Charlotte Storm Water  
600 East Fourth Street  
Charlotte, N C 28202-2844

## ***Rezoning Petition Review***

**Date of Review:** November 30, 2020 (***Revised December 28, 2020***)

**Rezoning Petition #:** 20-150

RZ1.0

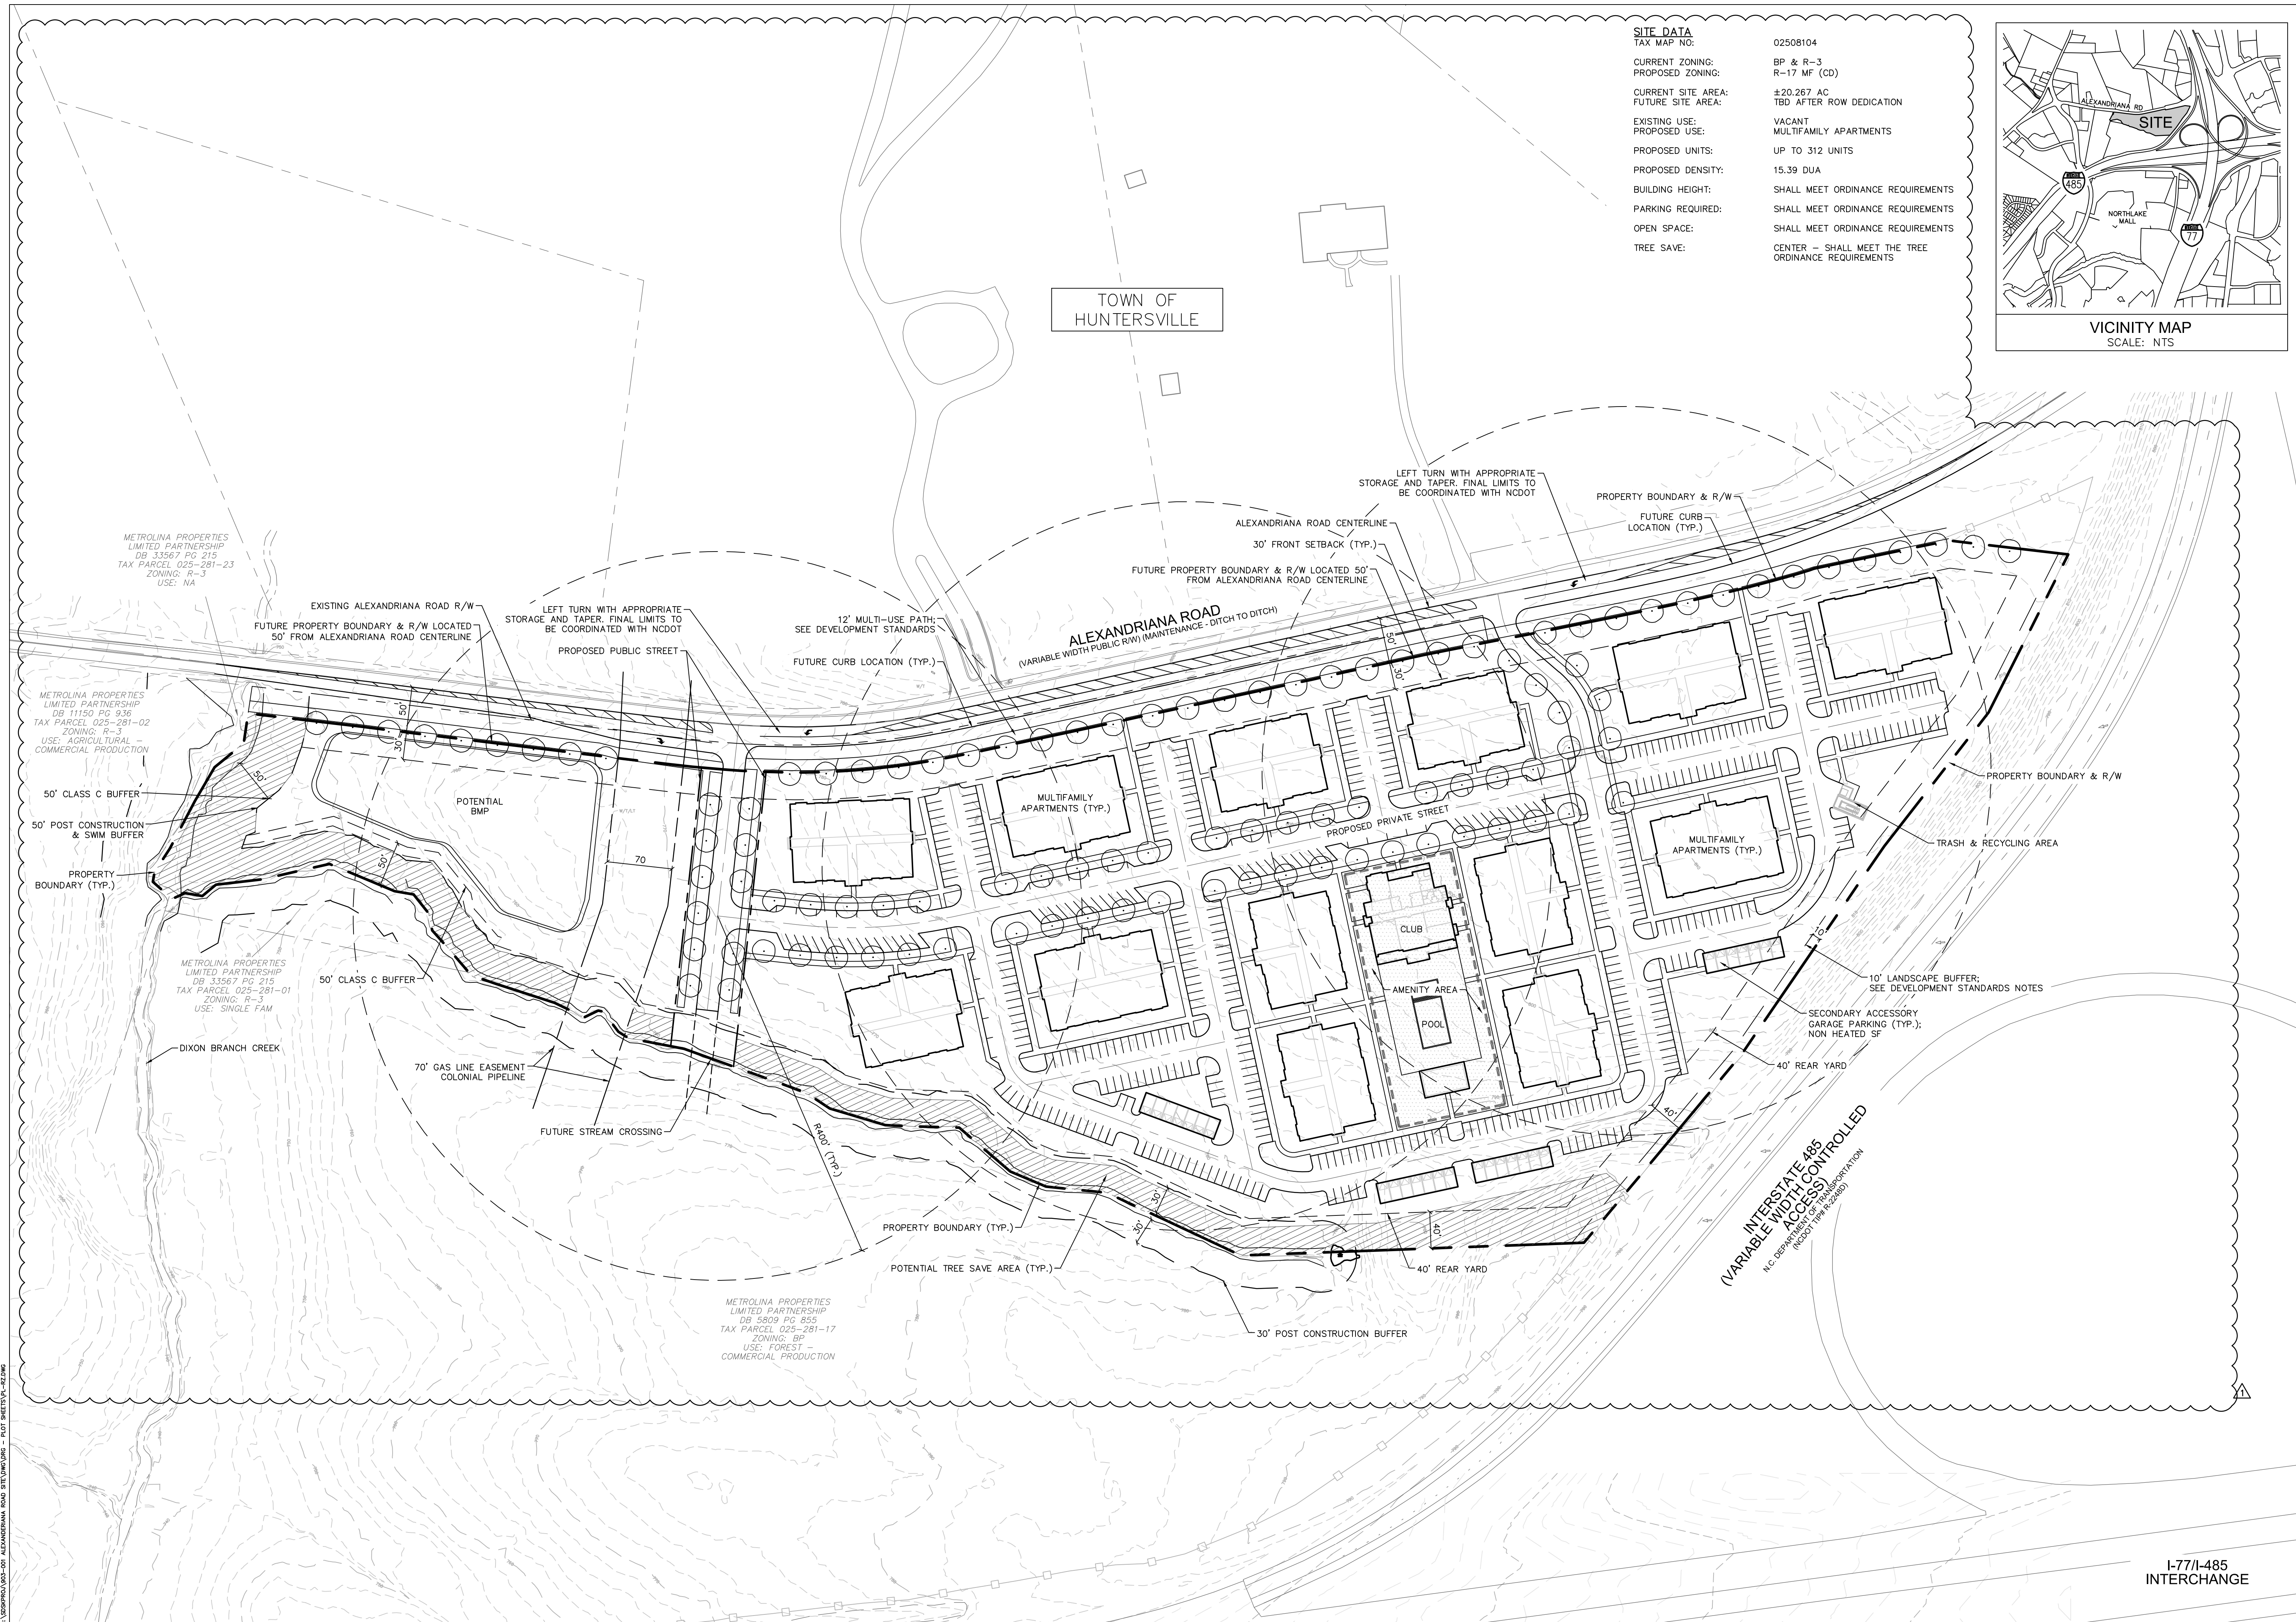
**Concerning Storm Water:** Please include the following note under Environmental Features:

*The location, size, and type of storm water management systems depicted on the Rezoning Plan are subject to review and approval as part of the full development plan submittal and are not implicitly approved with this rezoning. Adjustments may be necessary in order to accommodate actual storm water treatment requirements and natural site discharge points.*

**Due to revisions (12/28/20):** No additional recommendations are needed at this time.
